**The Planning Act 2008 - Section 89 and The Infrastructure Planning (Examination Procedure)
Rules 2010 - Rule 8 (as amended)
Application by Highways England for an Order Granting Development Consent for the A303
Sparkford to Ilchester Dualling**

From: Carleton Earl.
Area Footpath Secretary, Somerset Ramblers
Fulwood House
Winsham
Chard TA20 4EE

**The Planning Act 2008 - Section 89 and The Infrastructure Planning (Examination Procedure) Rules 2010 - Rule 8 (as amended)
Application by Highways England for an Order Granting Development Consent for the A303 Sparkford to Ilchester Dualling**

Drawing Title
**RIGHTS OF WAY AND ACCESS PLANS
REGULATION 5(2)(k) and 5(2)(o)
SHEET 1 OF 4**

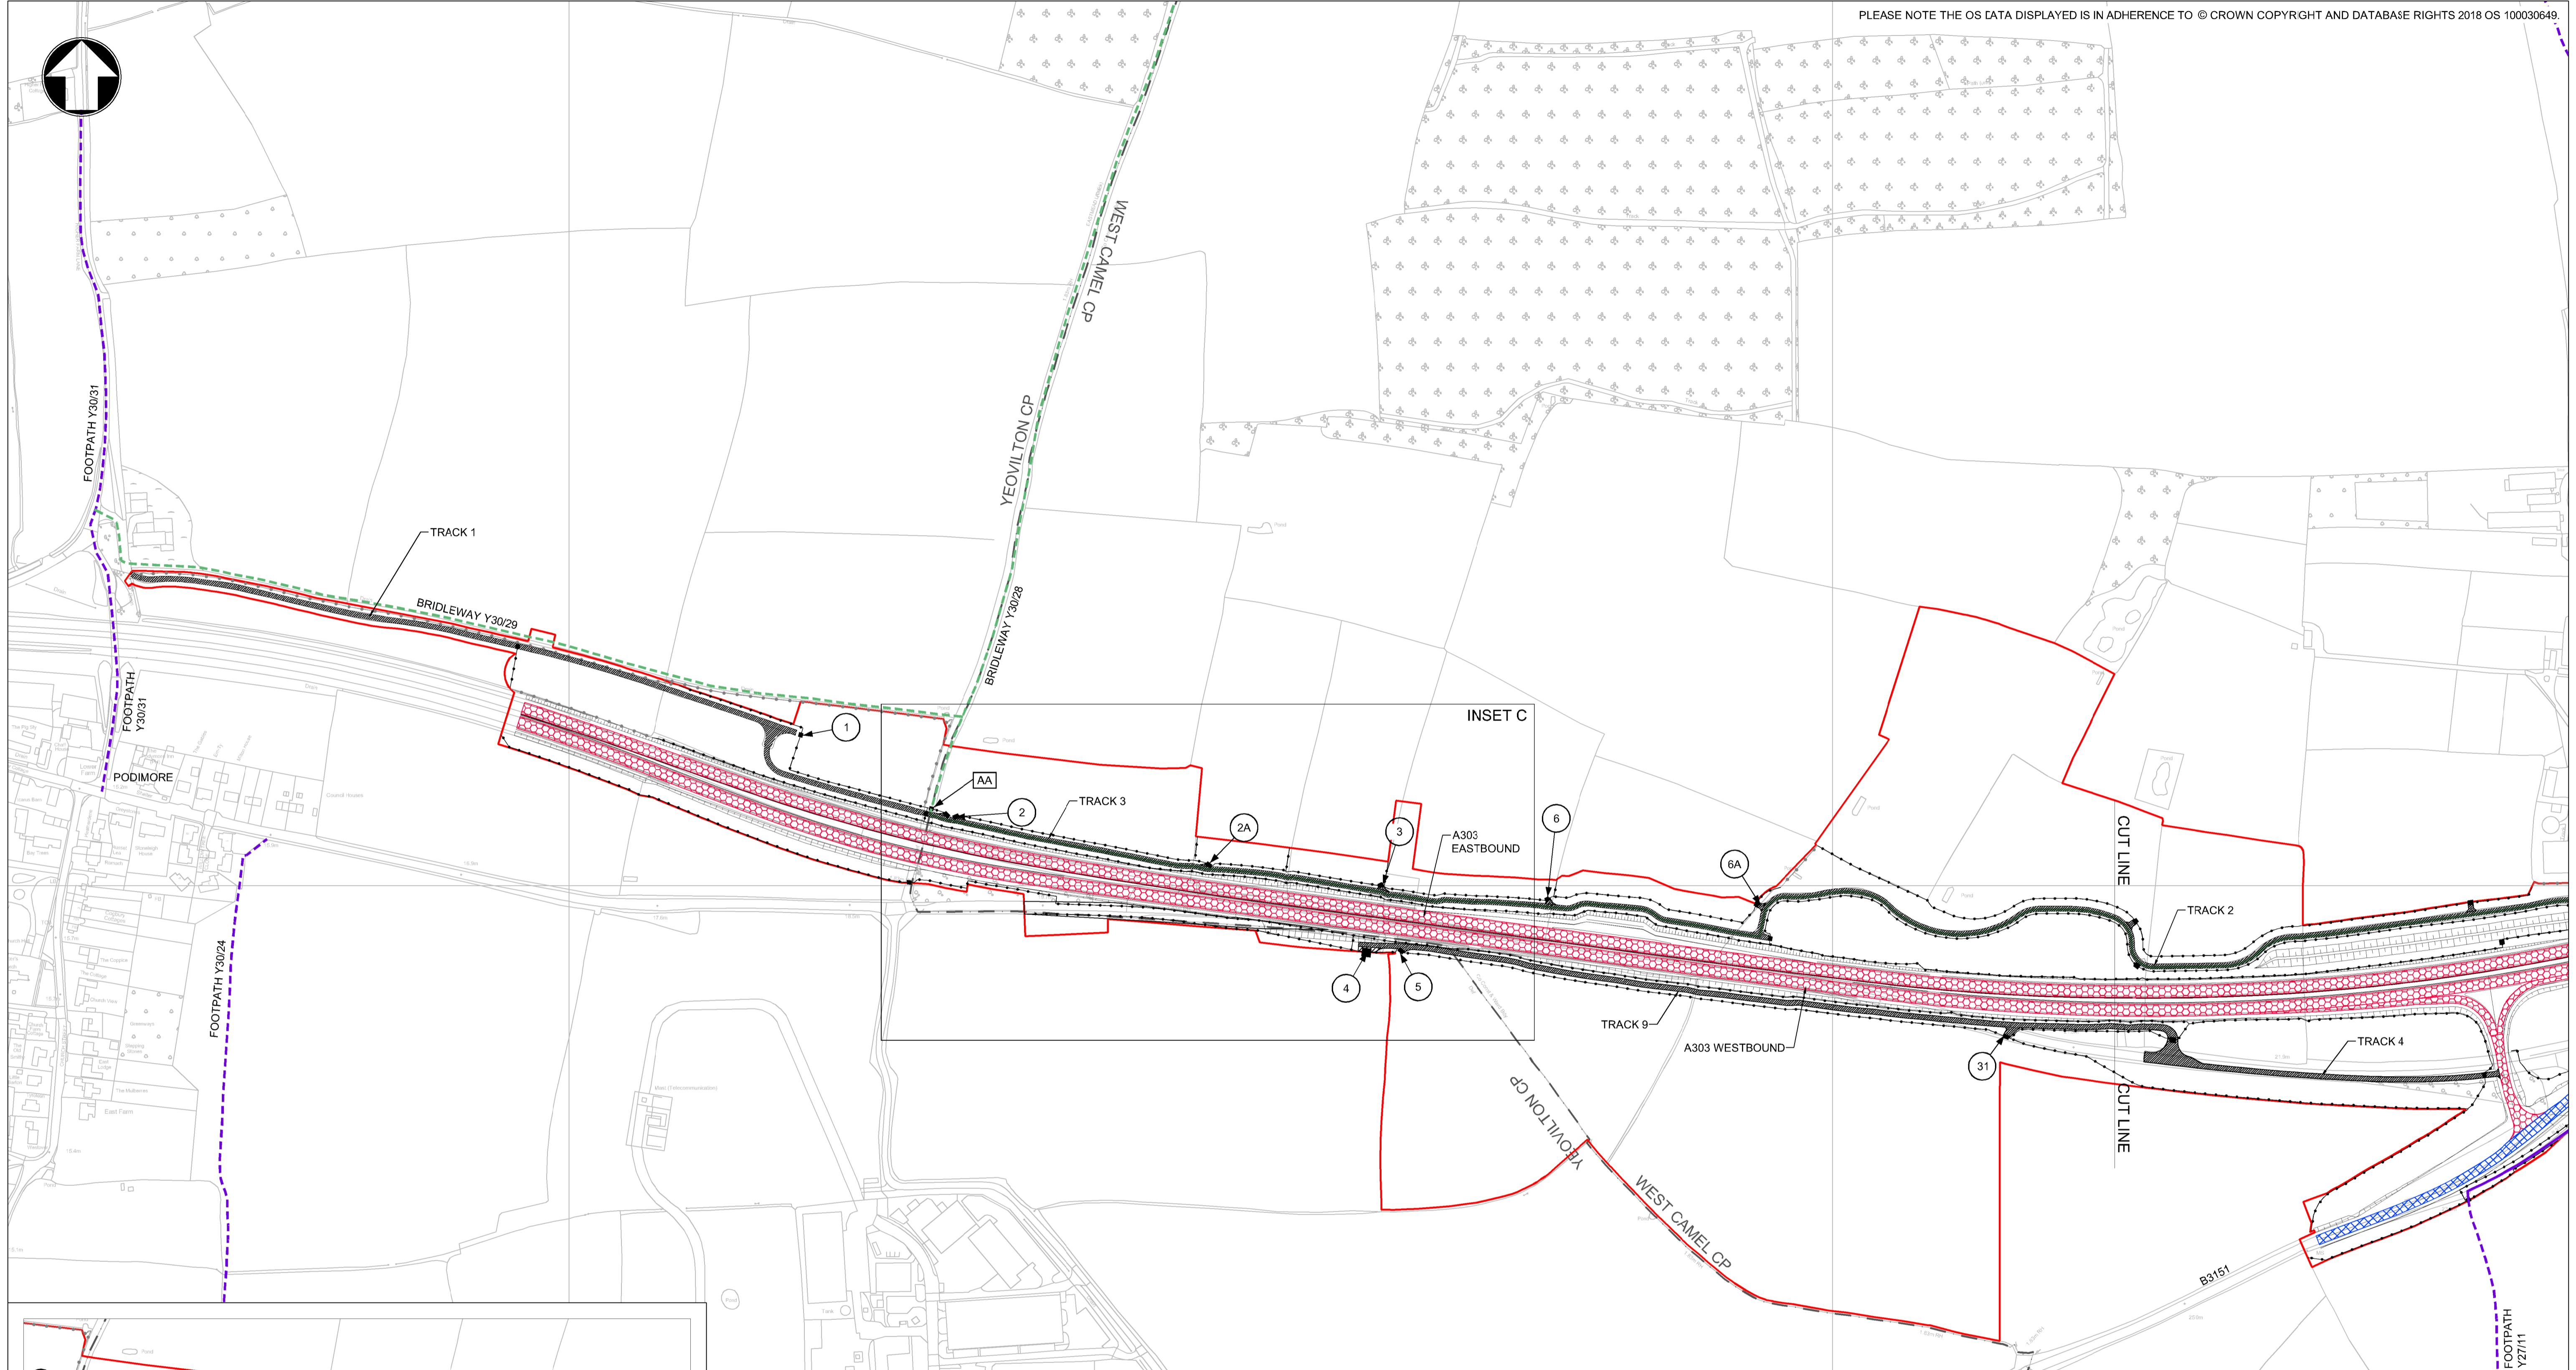
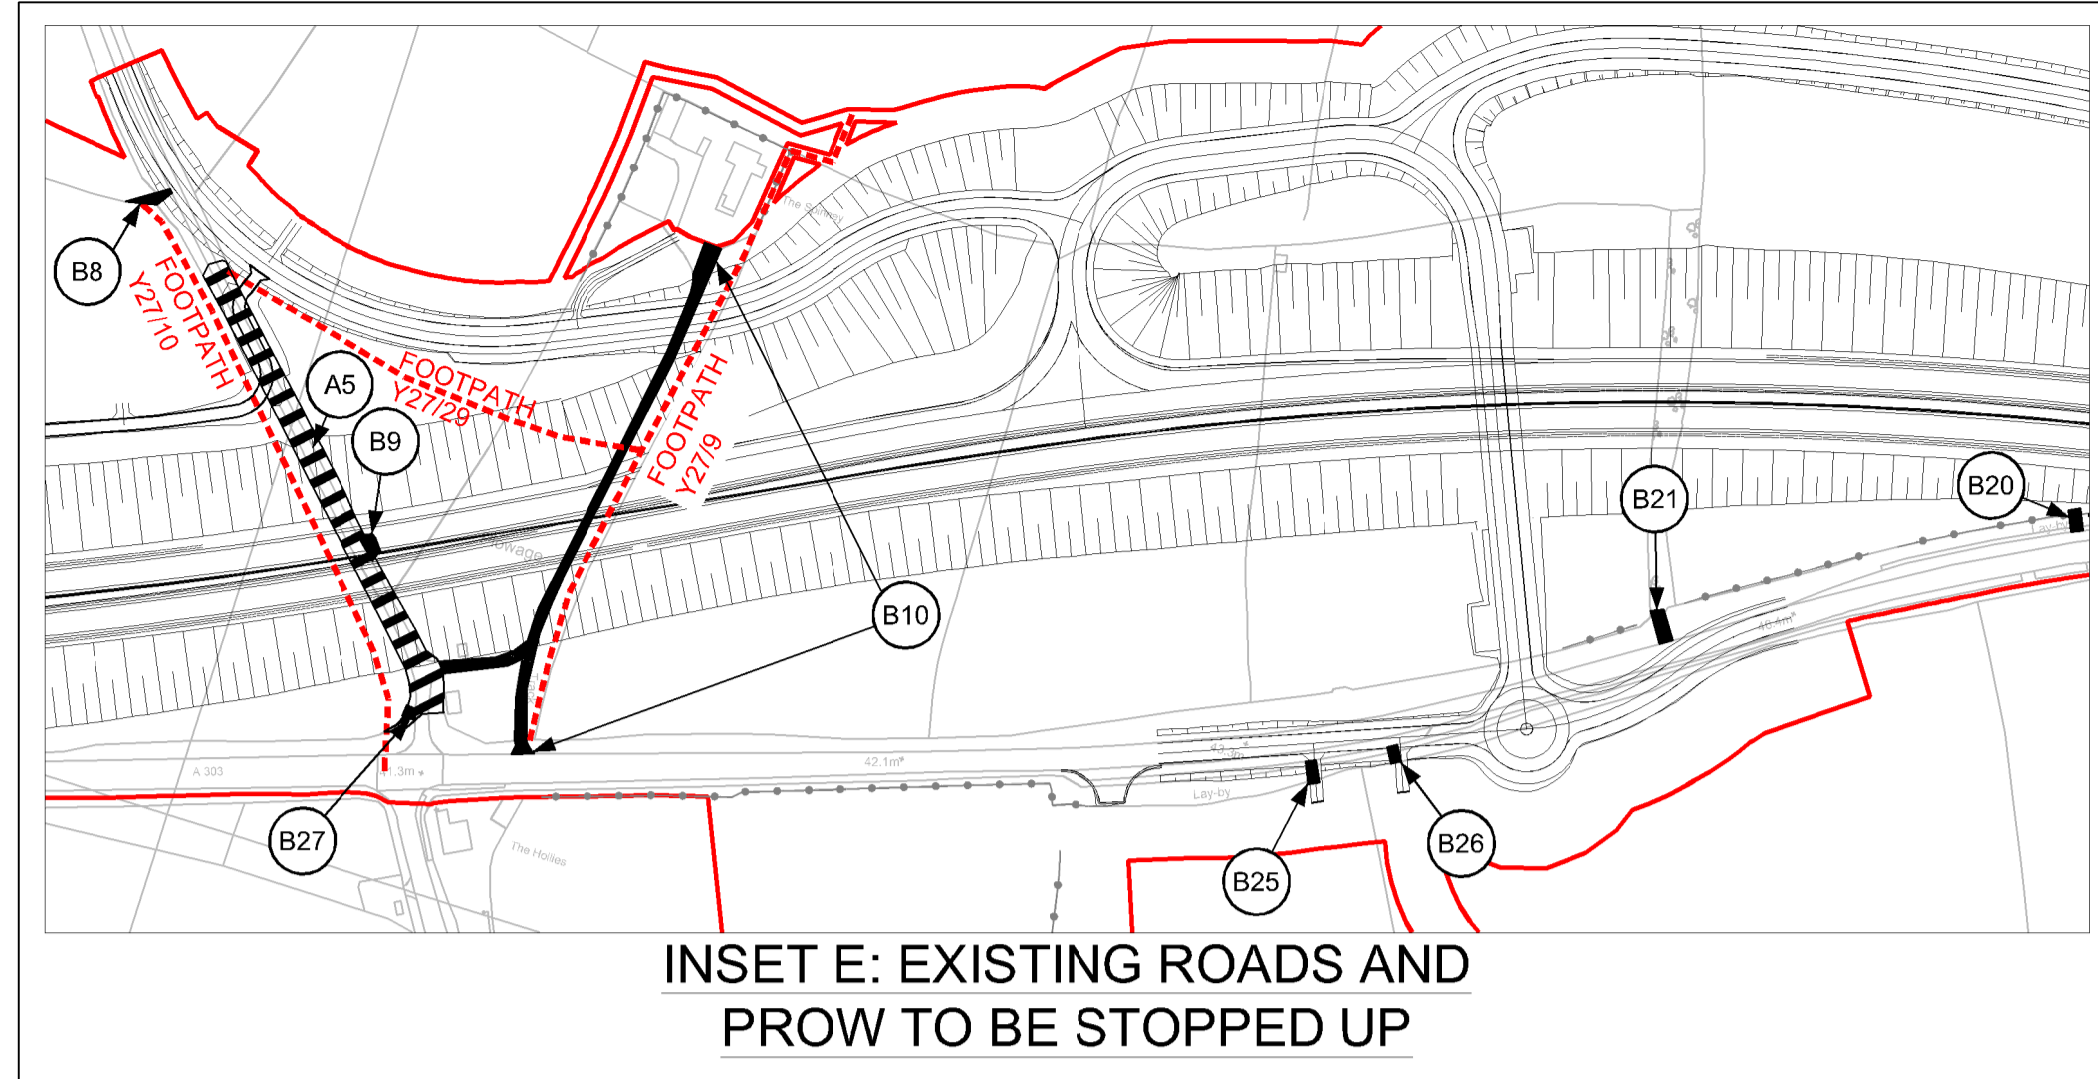
1. Part 1 of Schedule – West Camel – stopping up of un-named road at Camel Cross.
Somerset Ramblers would wish this section of road to be made a public footpath to provide a link to footpath Y 27/28 (shown on your plan as Y 27/UN) by the provision of a footbridge over the new road. This would provide an important link connecting routes north and south of the new road and not requiring a significant detour to the proposed new grade separated junction some way to the east.

3. Part 2 of Schedule – West Camel – stopping up of Footpath Y 27/UN (recorded by SCC as Y 27/28). This path, as set out in our 1 above, should be maintained to provide a connection over a new footbridge to the un-named road at Camel Cross to provide a convenient north to south link in the rights of way network without significant deviation.
